MERIDIAN RANCH: WINDINGWALK FILING 1 & 2

PUD DEVELOPMENT, PRELIMINARY PLAN AND FINAL PLAT FOR FILING 1

LETTER OF INTENT

JANUARY 2018, REVISED FEBRUARY 15, 2018

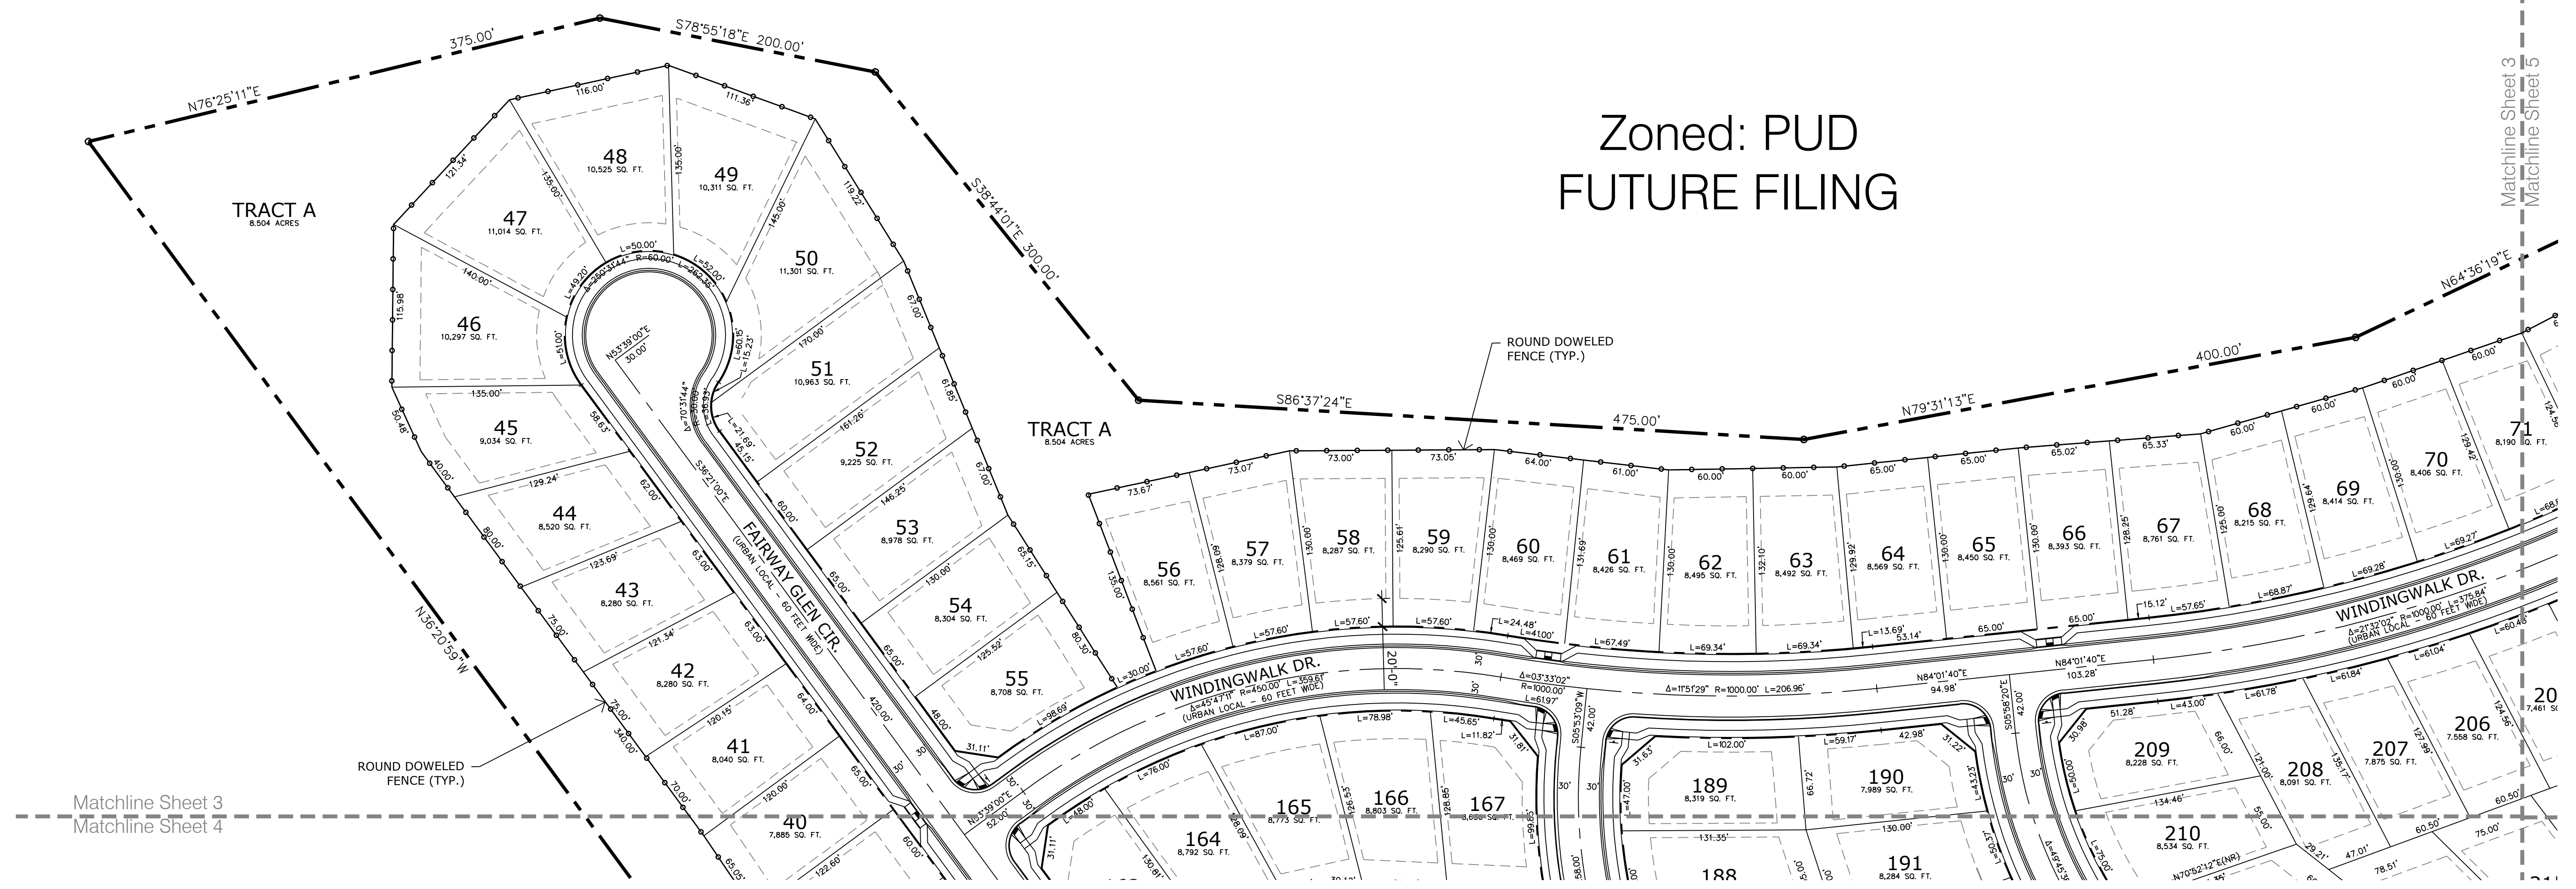
Comment 1 not addressed. Shade to show included in the PUDSP
